CITY OF ALBUQUERQUE

May 11, 2023

Re: MAS Charrter School/ West Parent Loop and Parking
99999 Yale Blvd. SE
Traffic Circulation Layout
Engineer's Stamp 04-17-23 (L16-D044)

SHEET NUMBER
TCL-01

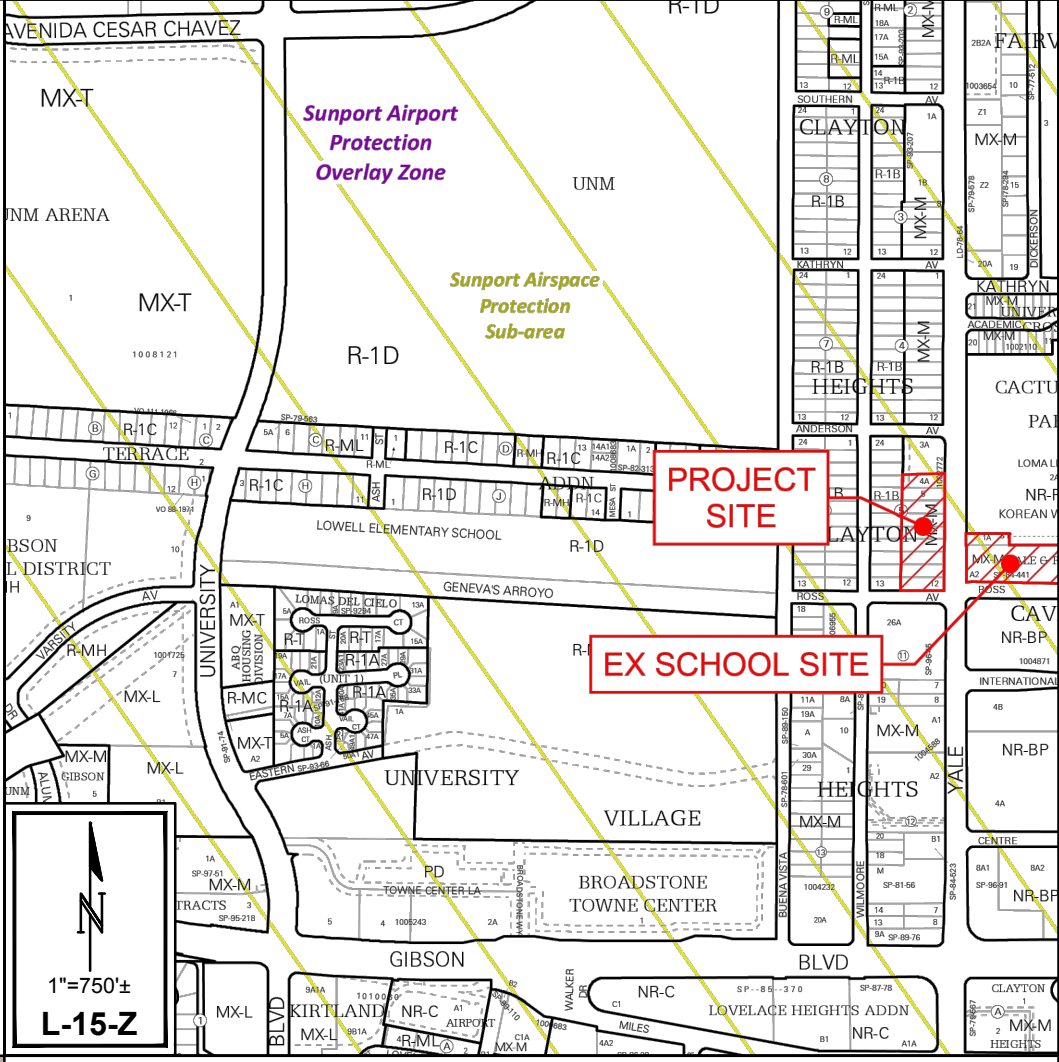
1. The traffic circulation layout must be signed by an engineer or architect licensed in the state of New Mexico.
2. Identify all existing access easements and rights of way width dimensions.

3. Driveway Accesses off Yale Blvd.:
 - Minimum accesses width should be 22 ft.
 - Both accesses must be updated to the current ADA standard.
 - Show on the site plan the required turned around before the gate (min. 20 ft. set back).

4. ADA curb ramp at the corner of Yale Blvd. and Ross Ave. must be updated to current standards and have truncated domes installed.
5. The pavement marking "MC" should be shown in the opposite direction for motorcycles entering the parking space.

6. Per DPM, a 6 ft. wide ADA accessible pedestrian pathway is required from the ADA parking stall access aisles to the building entrances. Please clearly show this pathway and provide details.

7. All one-way drives shall have "One Way" and "Do Not Enter" signage and pavement markings. Please show detail and location of posted signs and striping.

8. The minimum drive through lane width is 12 feet with a 25-foot minimum radius (inside edge) for all turns. (A 15-foot radius can be used with an increase in lane width to 14 feet). Please dimension all lane widths and radii.

9. Clear sight triangle should start at the back of the sidewalk. Please revise the site plan.
10. Please specify the City Standard Drawing Number when applicable.

11. Provide notes showing what work is included and on the work order and the private work on site.

12. Please add a note on the plan stating "All improvements located in the Right of Way must be included on the work order."
13. Unused curb cuts must be replaced with sidewalk and curb & gutter. A build note must be provided referring to the appropriate City Standard drawing.

14. Add a note stating "All broken or cracked sidewalk must be replaced with sidewalk and curb & gutter." A build note must be provided referring to the appropriate City Standard drawing.
